Recommendation Report for Planning Permission**REF NO:** CM/23/17/PL**LOCATION:** Land at Entrance to Waterford Gardens
Horsemere Green Lane
Clymping**PROPOSAL:** Erection of 1 No. dwelling with detached garage (resubmission of CM/29/14/PL).
This application is a Departure from the Development Plan.**SITE AND SURROUNDINGS**

Site Plan

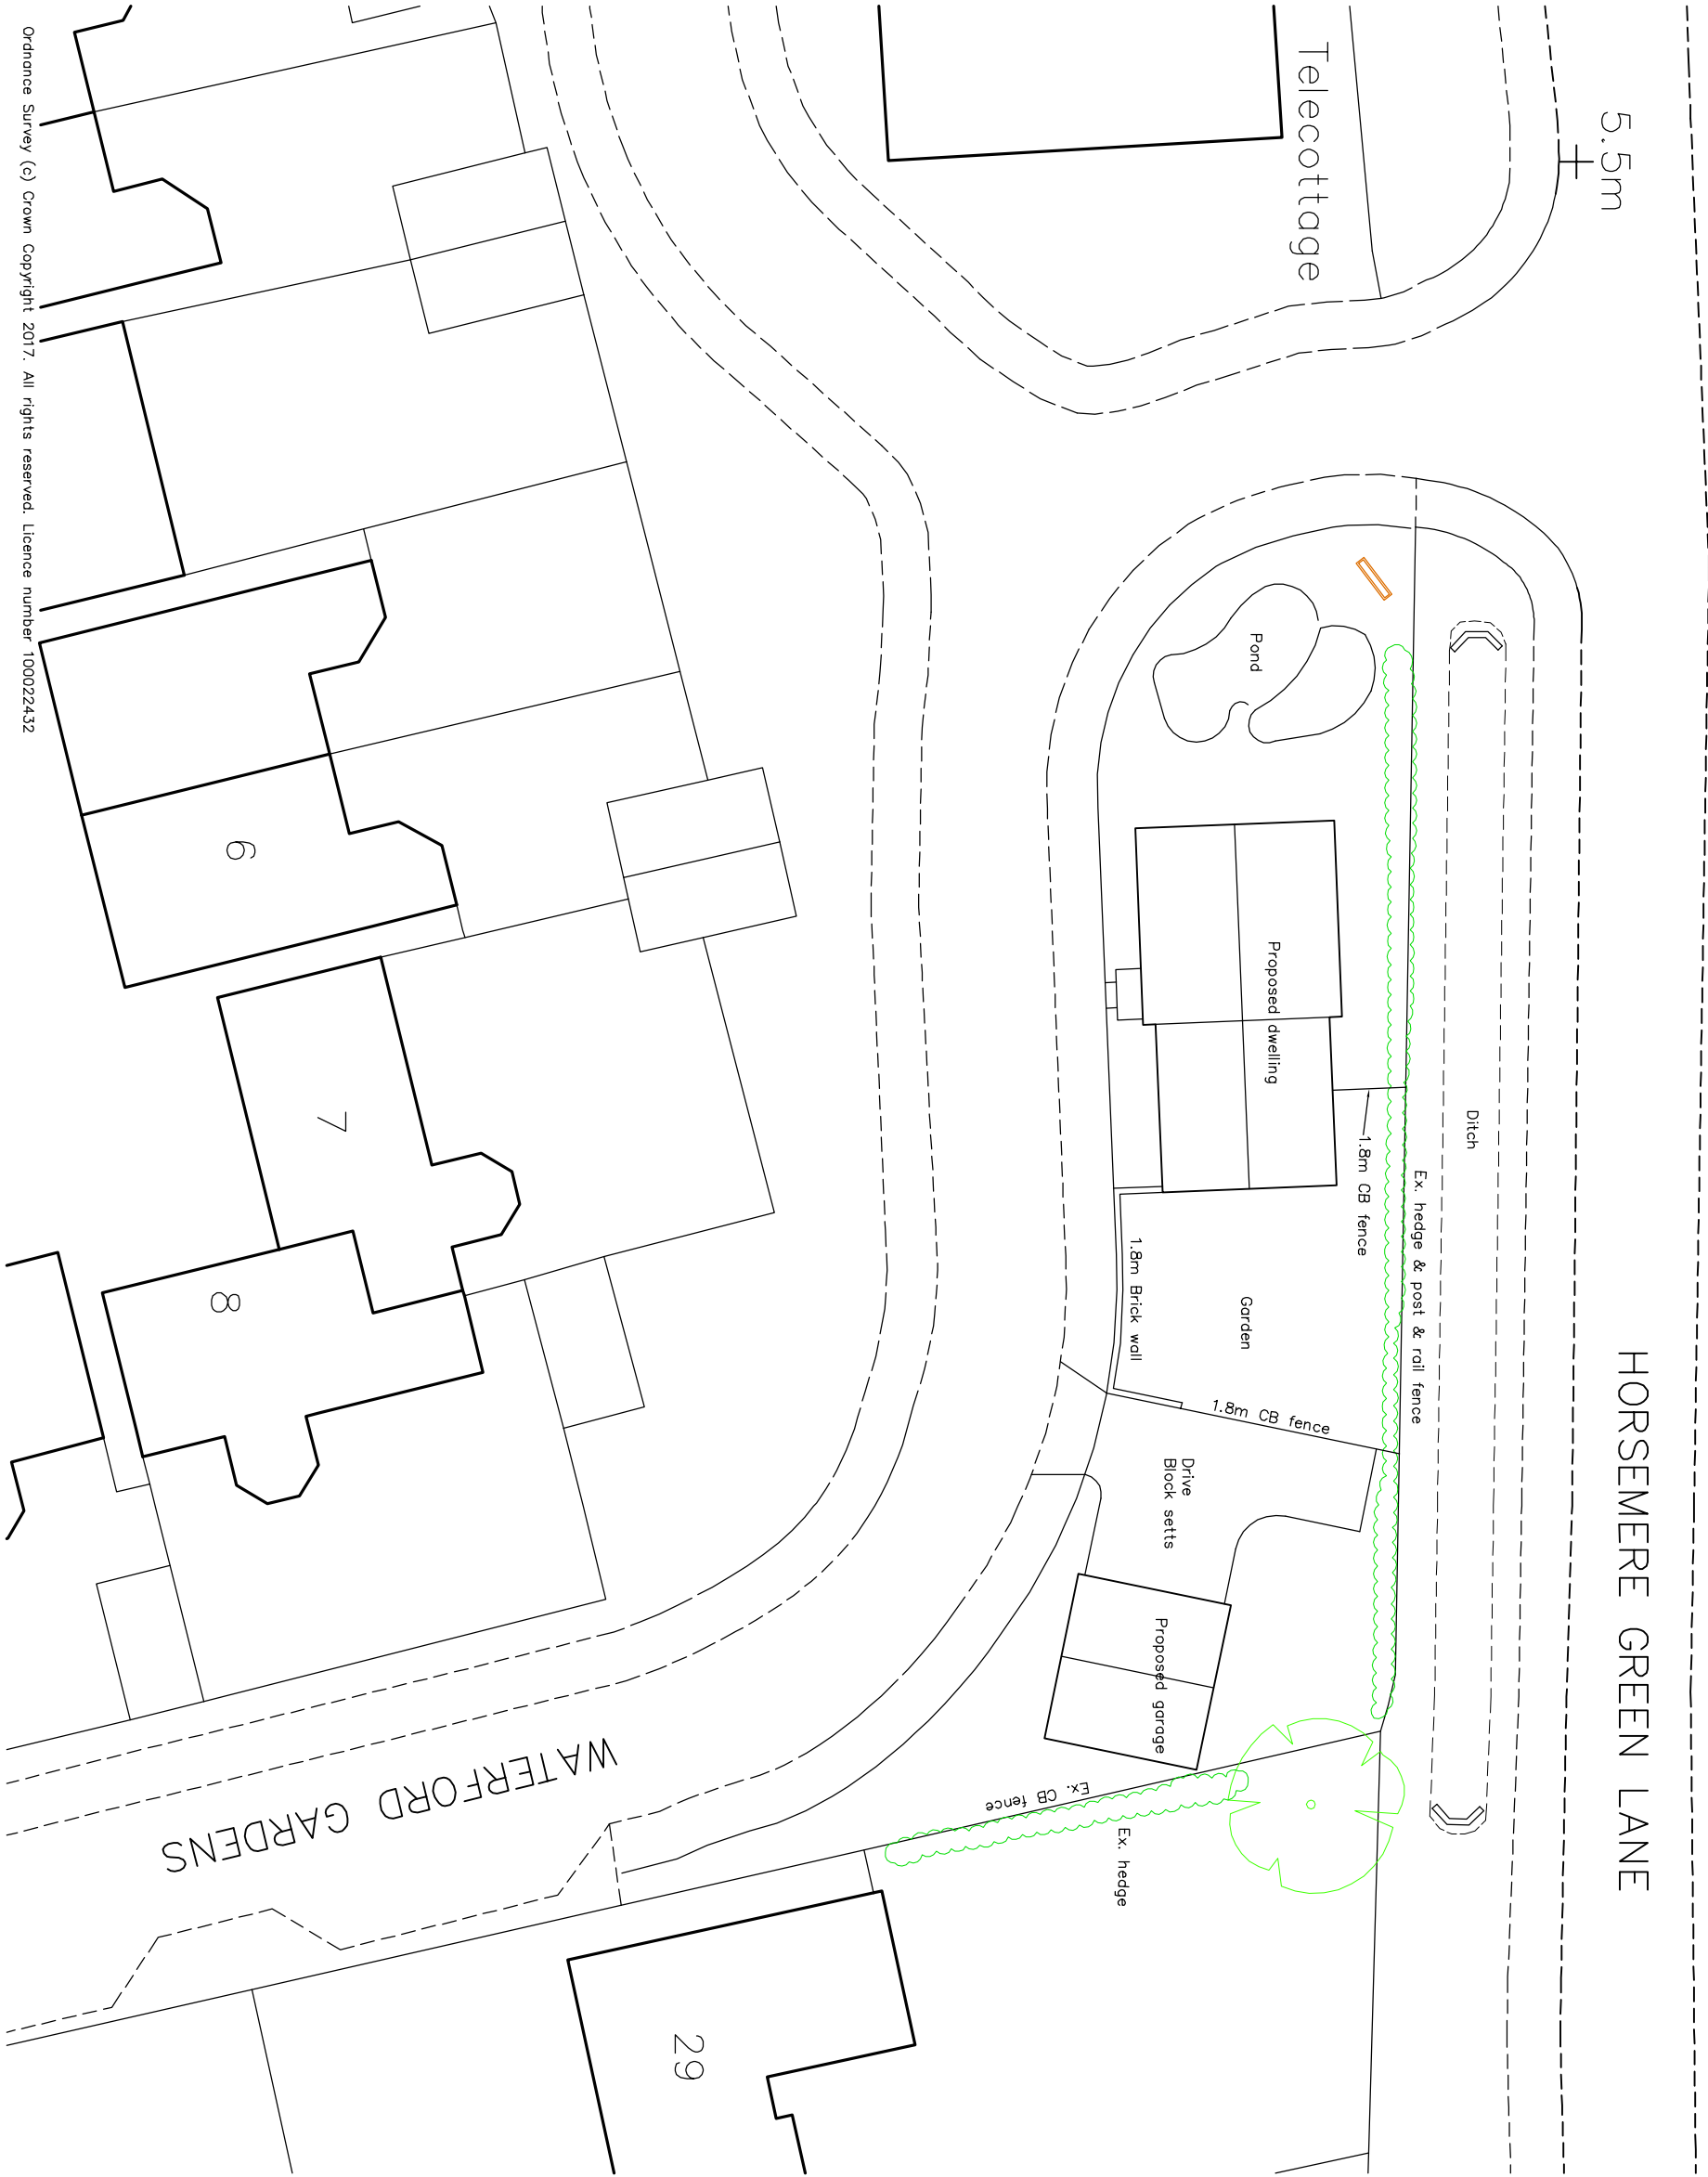
Trees shown on the block plan to the east do not exist. 29 Cropthorne Drive is not indicated on the block plan. There is no indication of ground levels or below surface drainage which will affect adjoining properties.

Not all spaces to boundary from the garage are dimensioned

The presence of trees outside the application site is not relevant to consideration of the application since they are not in the applicant's ownership. The site has been visited and it is apparent they do not exist. Whilst 29 Cropthorne Drive is not shown on the block plan it is indicated on the site plan which can be scaled and used to assess the impact of the garage on the adjoining property.

It is not considered that the proposal represents overdevelopment. The plot size is readily comparable with other plots in the locality. The distance to boundaries does not need to be provided. They can be scaled. There has been no objection from West Sussex County Council Highways department regarding the highway safety issues at the site. The garden area exceeds 20m in depth which meets the External Space Standards requirements and is considered to be in-keeping with existing development. The remaining points regarding the design of the proposed dwelling are discussed in more detail in the Conclusions section of this report.

Double Garage

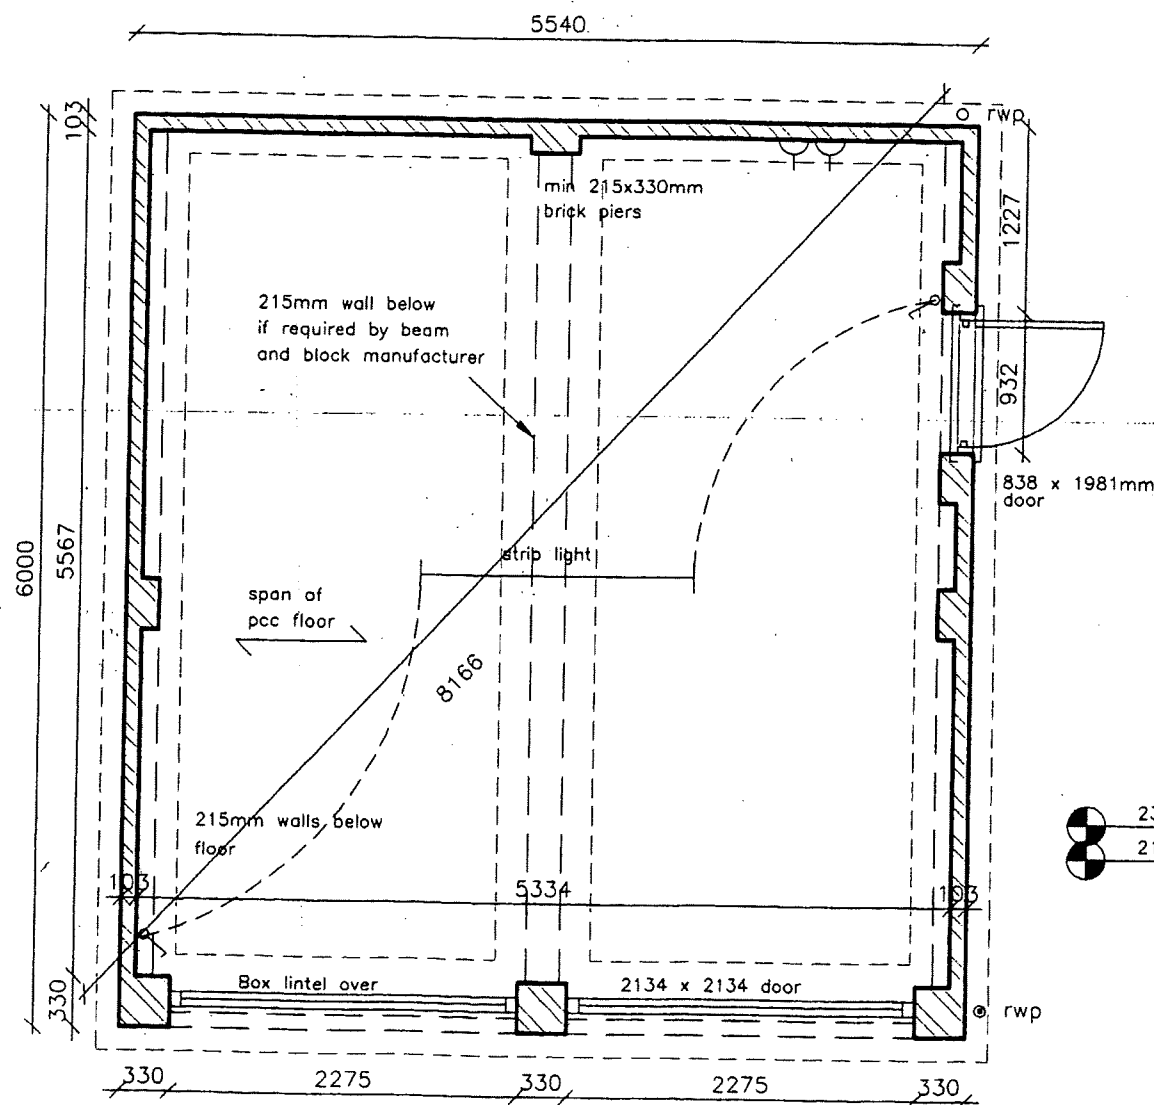
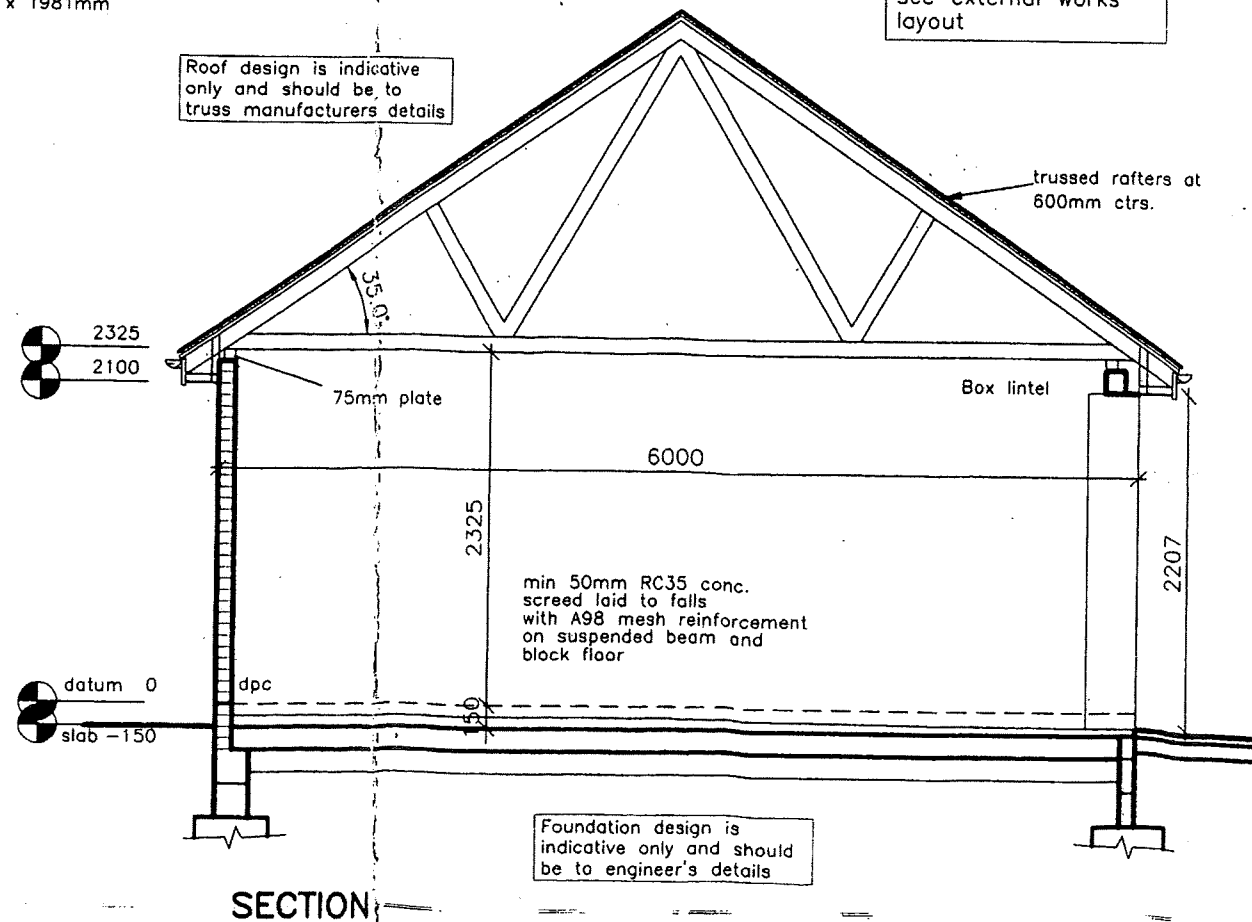
Whilst the detached double garage measures approximately 4.6m in height and is in relative close proximity to the rear eastern boundary, there is close boarded fencing and hedging/trees at over 2m in height which will shield part of the structure and has a pitched roof design which will slope away from the boundary.

It is therefore considered that the proposed dwelling and double garage will not cause any harmful overshadowing or overbearing effects, or any unacceptable overlooking or loss of privacy.
